2003-0050
Application I. D. Number
03/11/2003
Application Date
24 Jewel Rd. Peaks Island
Project Name/Description

RE: 24 Jewel Road, Peaks Island - 089-F-007 - IR-1 Island Residential Zone

I am in receipt of your permit application for a new single family dwelling at 24 Jewel Road, Peaks Island. Your application does not have all the necessary documentation for which to do a full zoning review.

C&P Auger
 089-F-007
 24 Jewel Rd

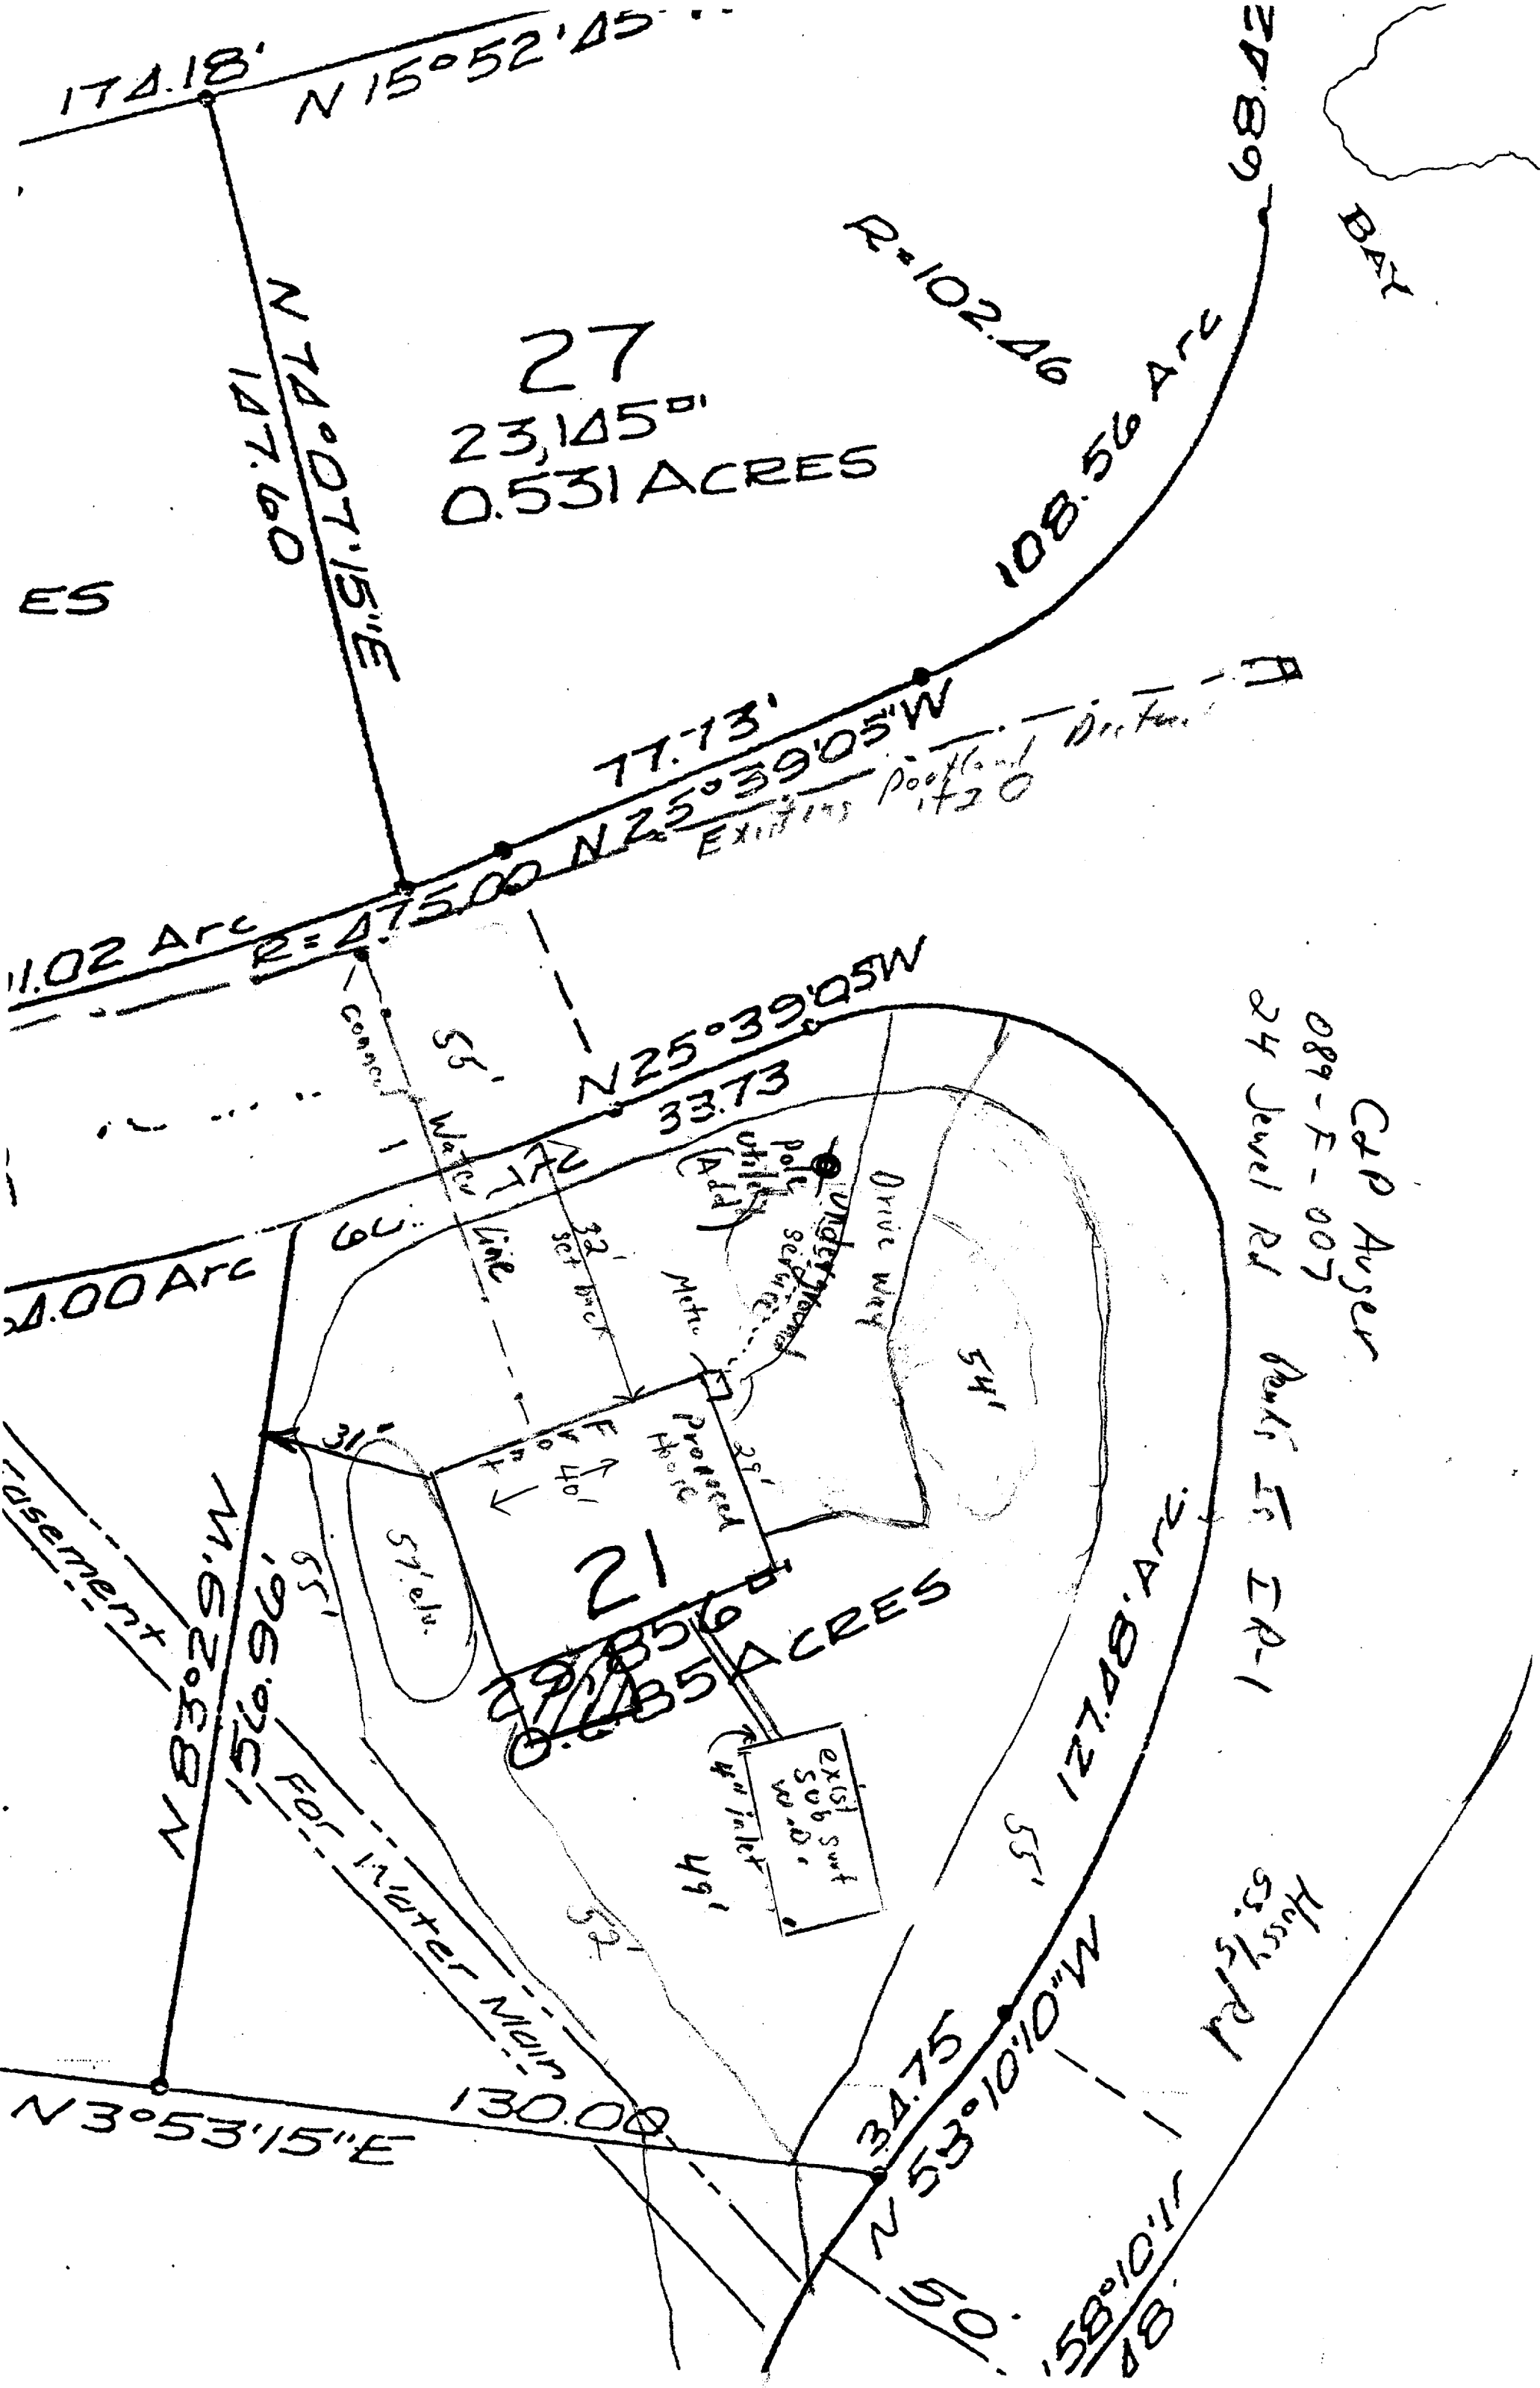
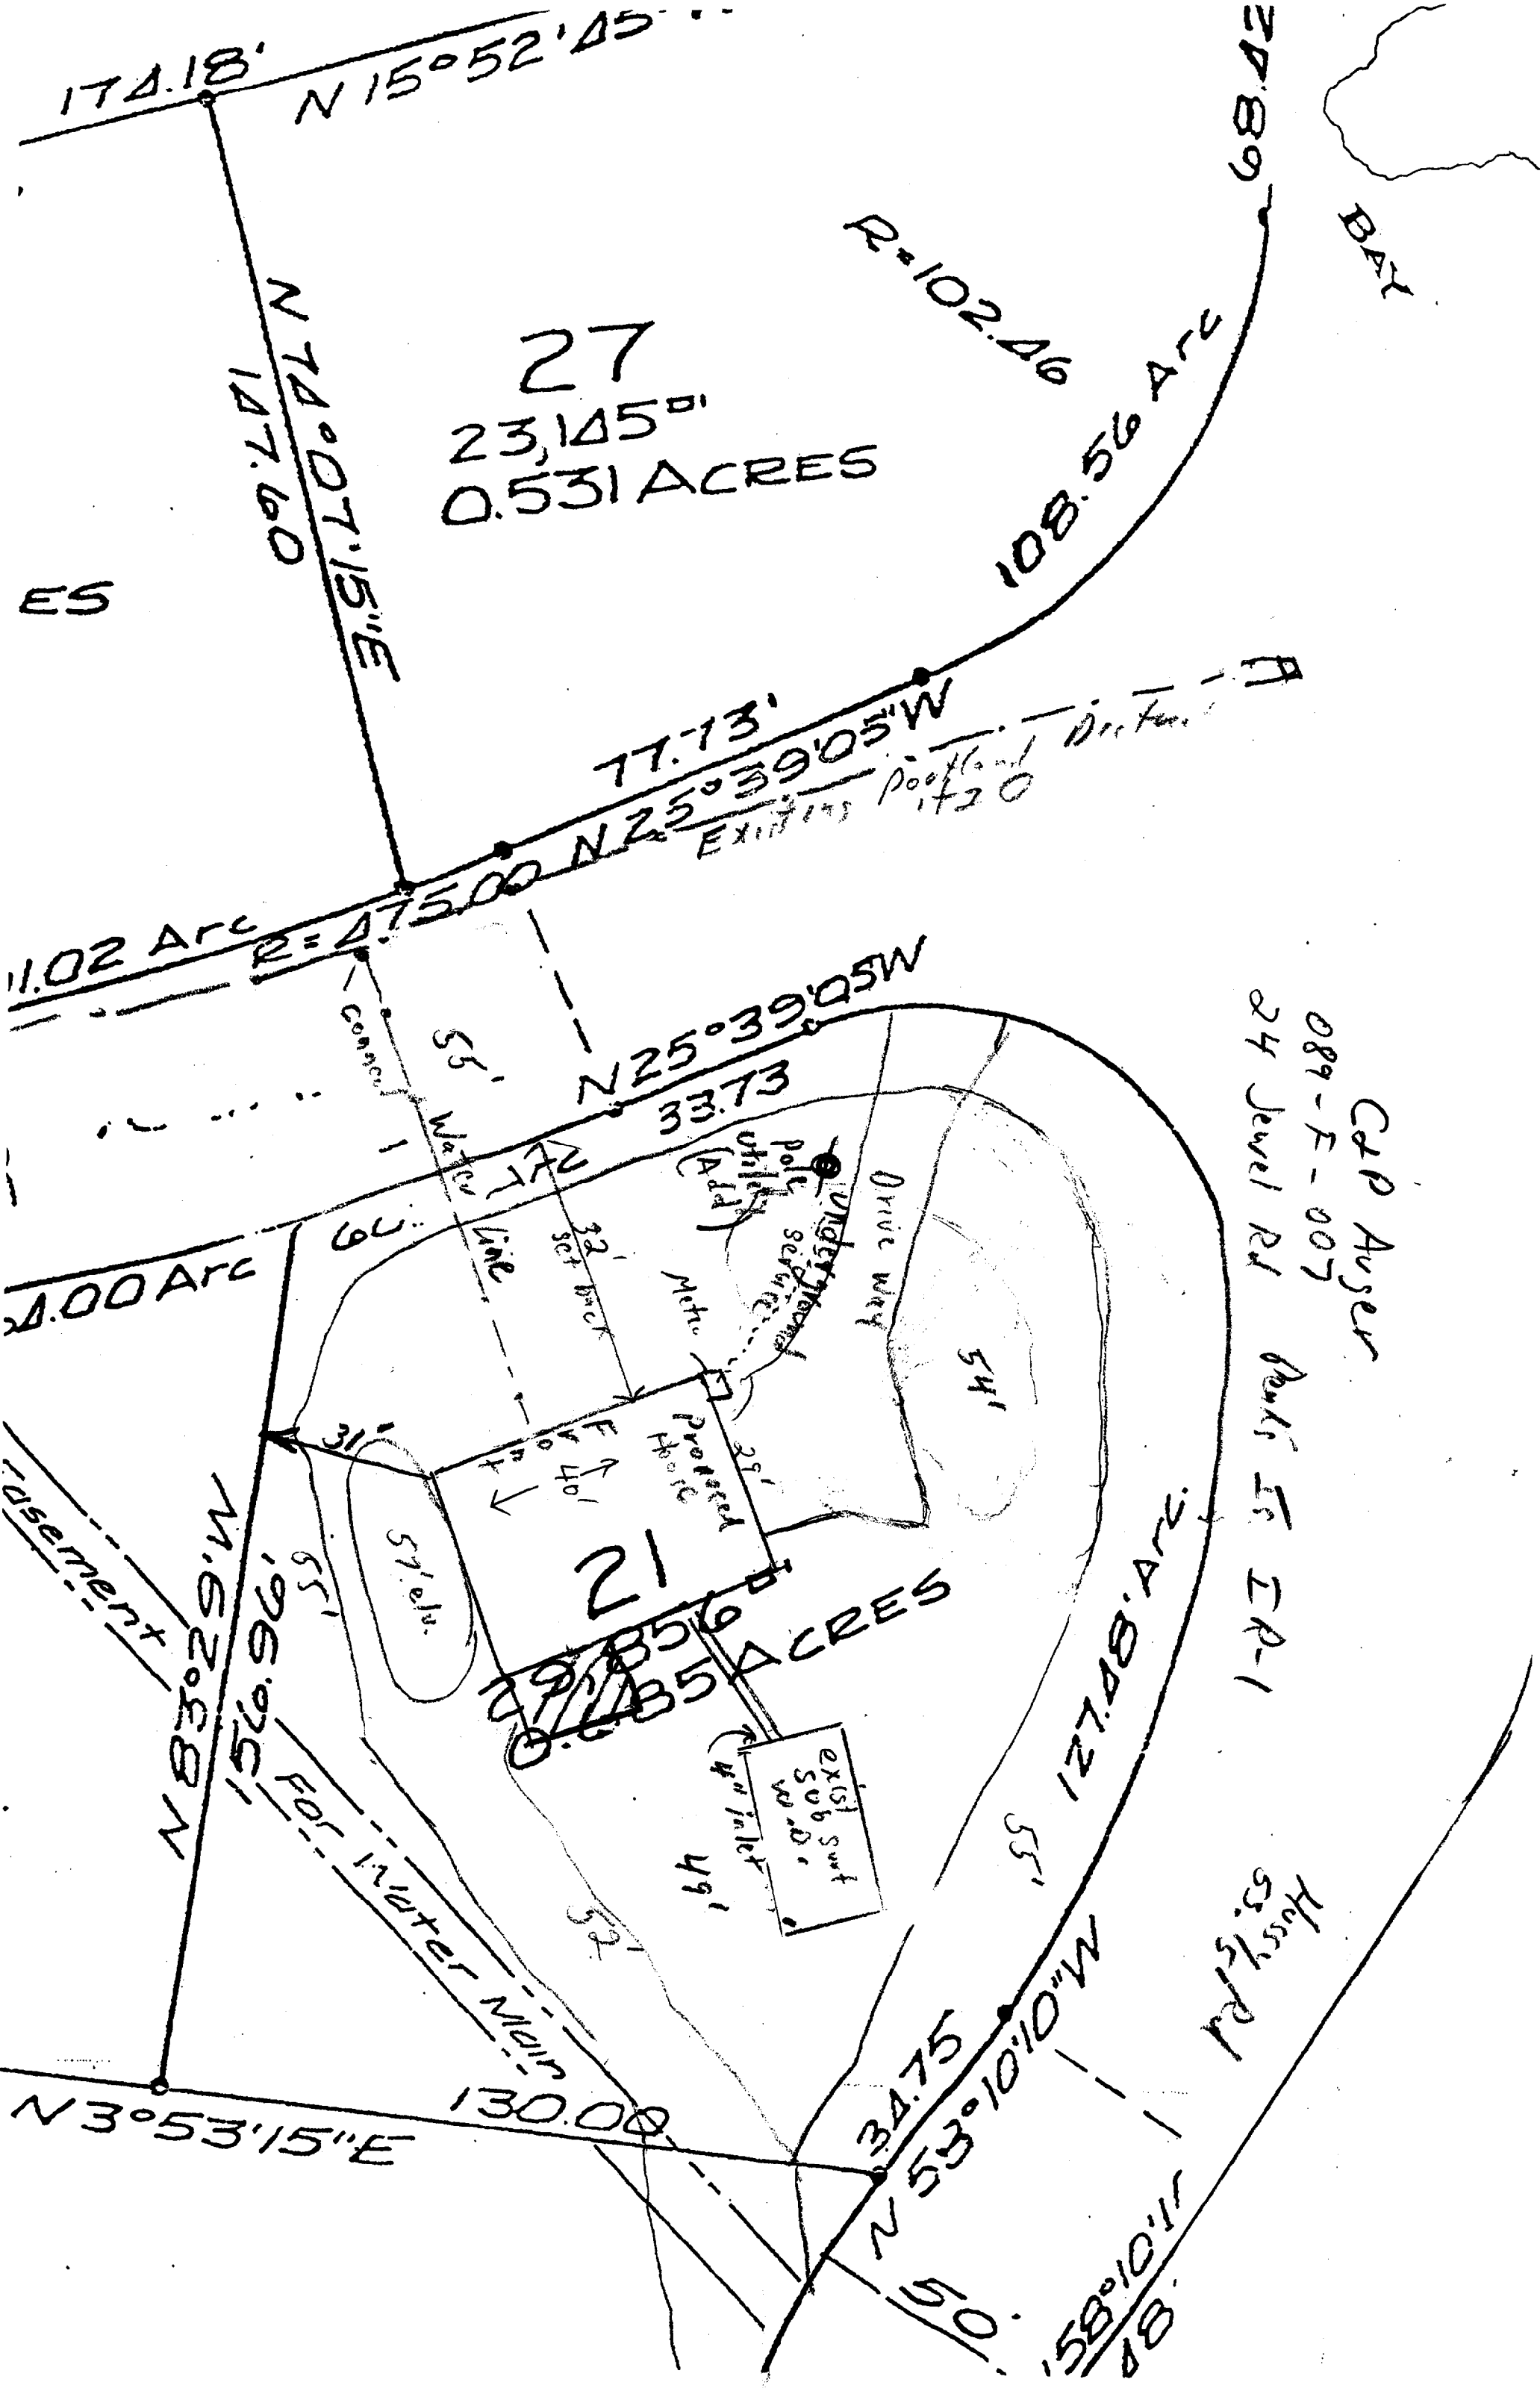
I will also need an accurate, stamped site plan (two copies) with all dimensional setbacks shown. You submitted an enlarged assessor's map with a building plopped down on it. Your site plan also needs to show predevelopment grades and post development grades. These grades are required both for the development review coordinator to review and for zoning purposes to determine that maximum height limits are being met.
